Your Ref: OWPC18035
Our Ref: EG/107/17/DOC 21-12-2017
Please ask for:
Mr S Davis

27th April 2018

Application for approval of details reserved by condition imposed under planning application EG/38/15/PL relating to condition No. 3 - Surface water drainage
97 Barnham Road Eastergate

Number
S17-03-01 E

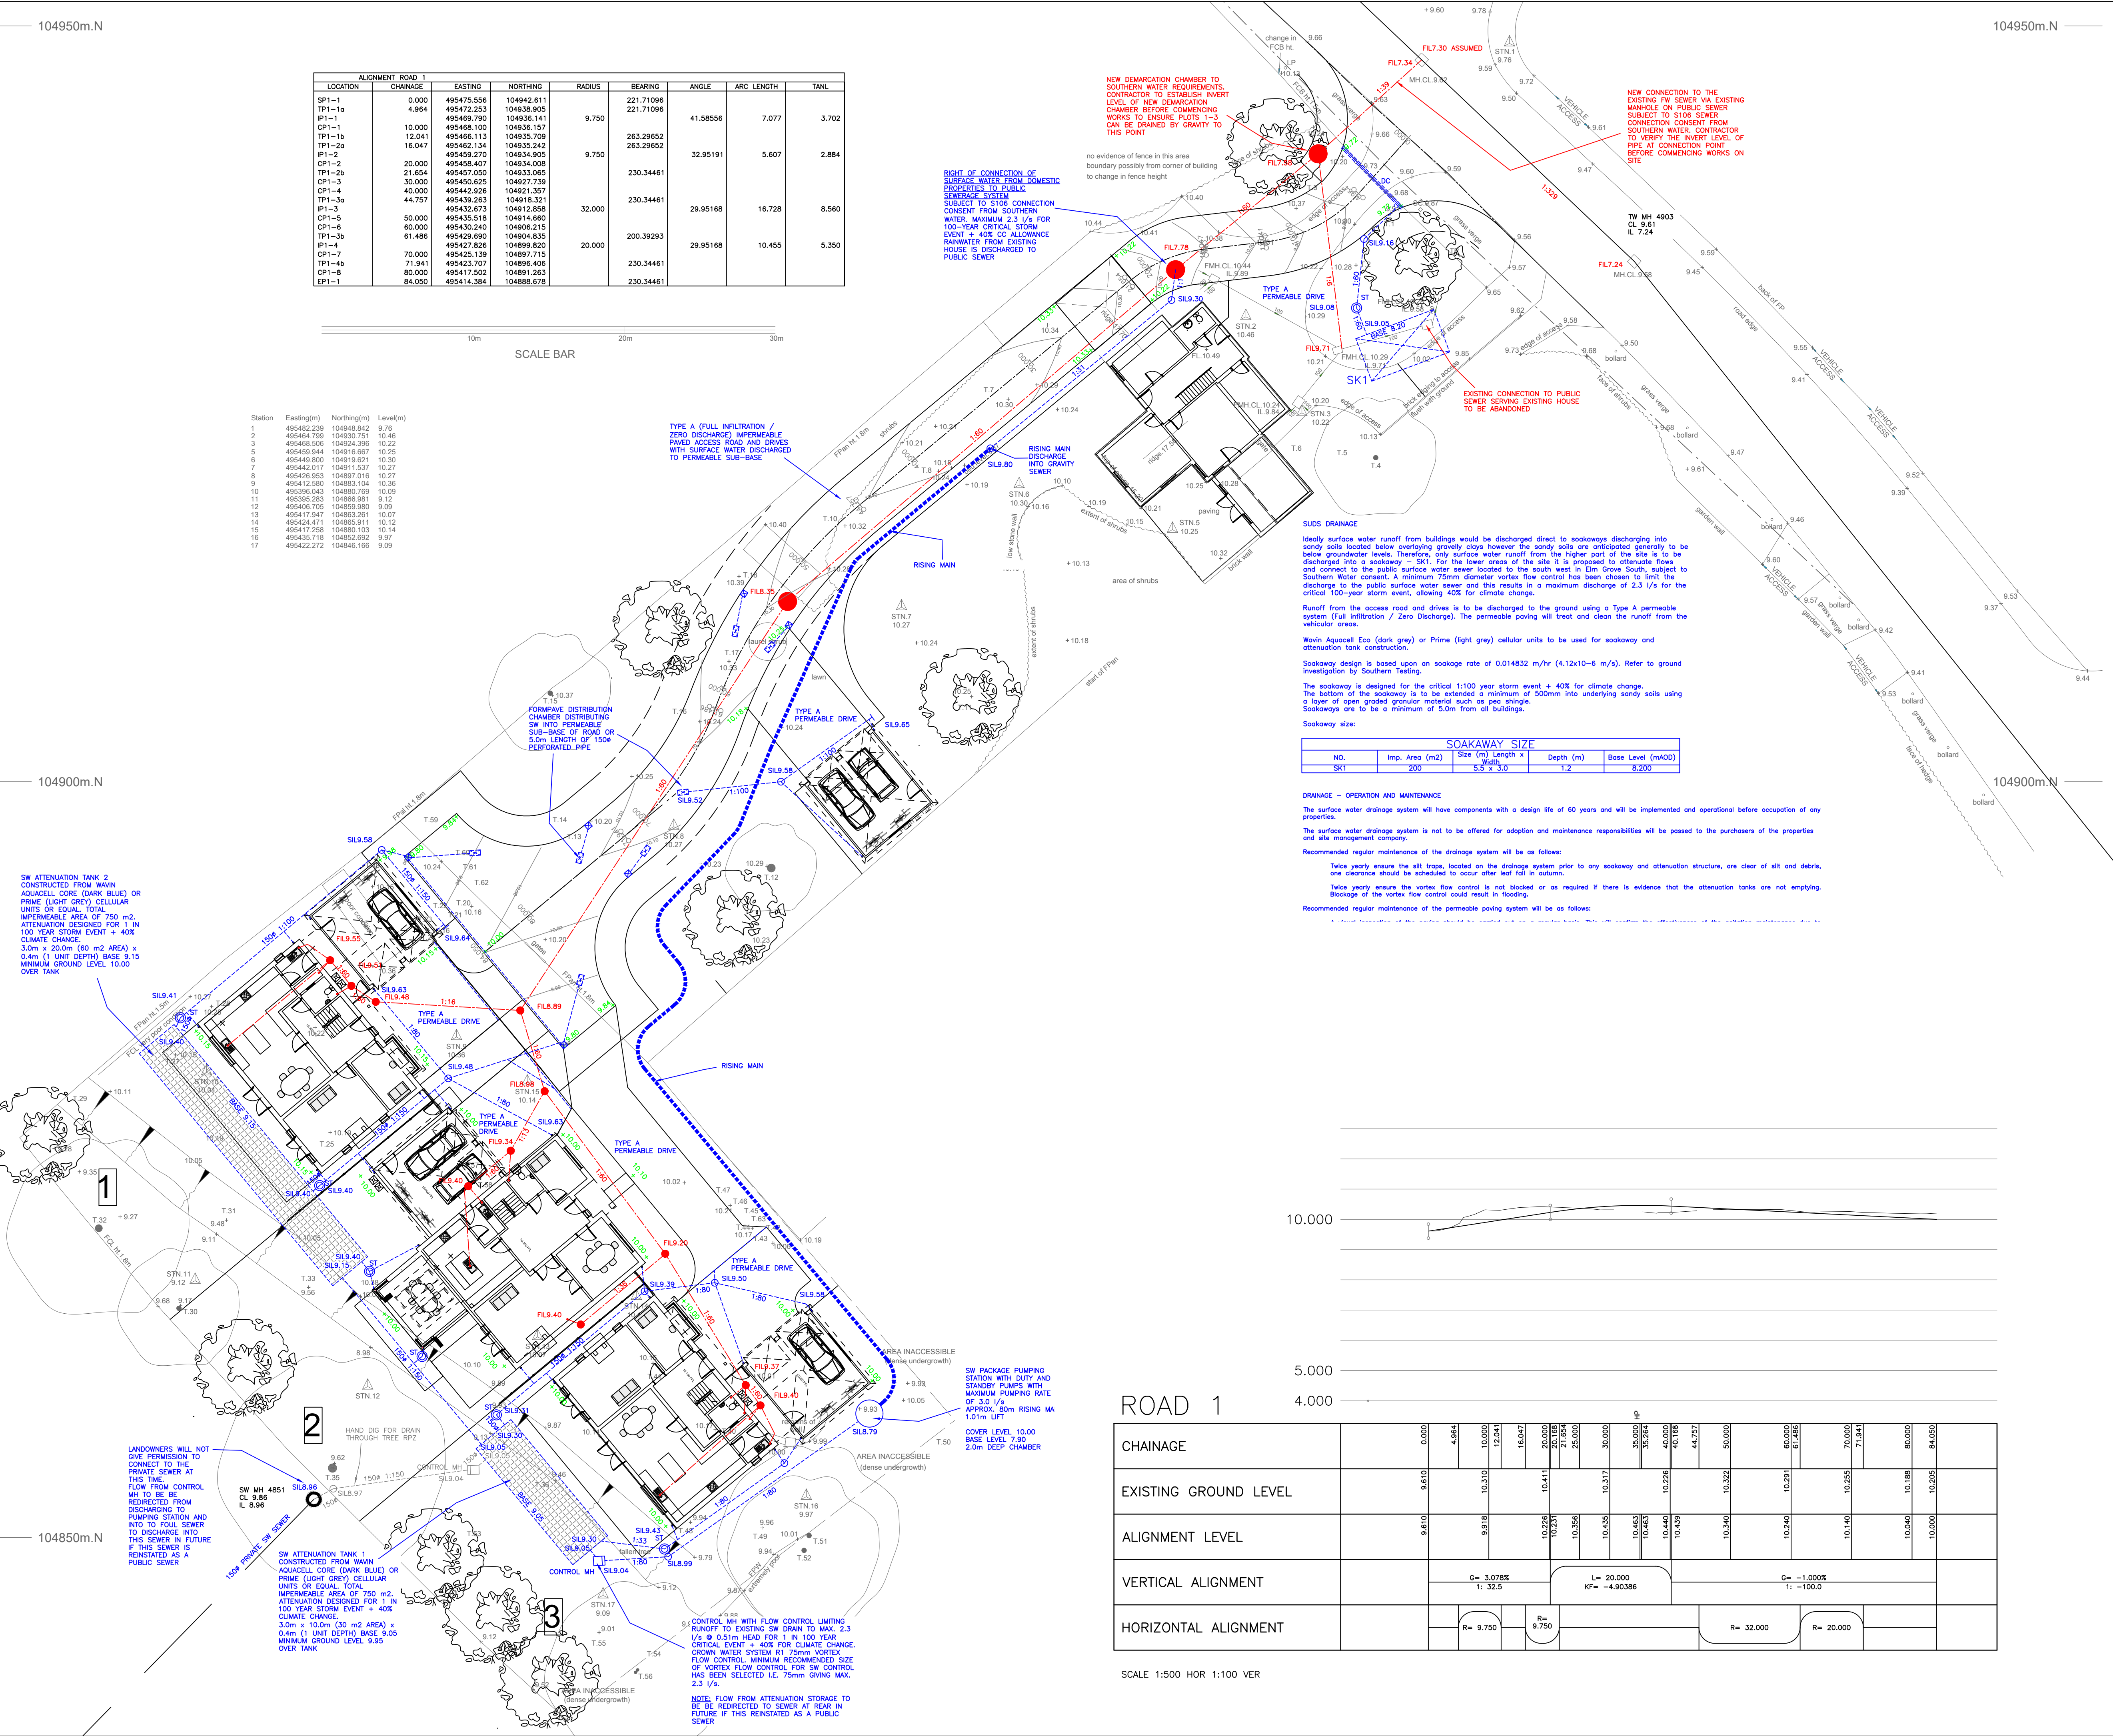
i have reported to simon davis that there is a problem with a hole that has appeared to the rear of plot 3 between the boundary fence and the fence erected to the rear of plot3 this hole is getting larger there is also an area that has collapsed i have asked for this to be inspected but this has not been done i can only assume that this is a drainage issue and that the soil is being washed away to what extent one can only guess.
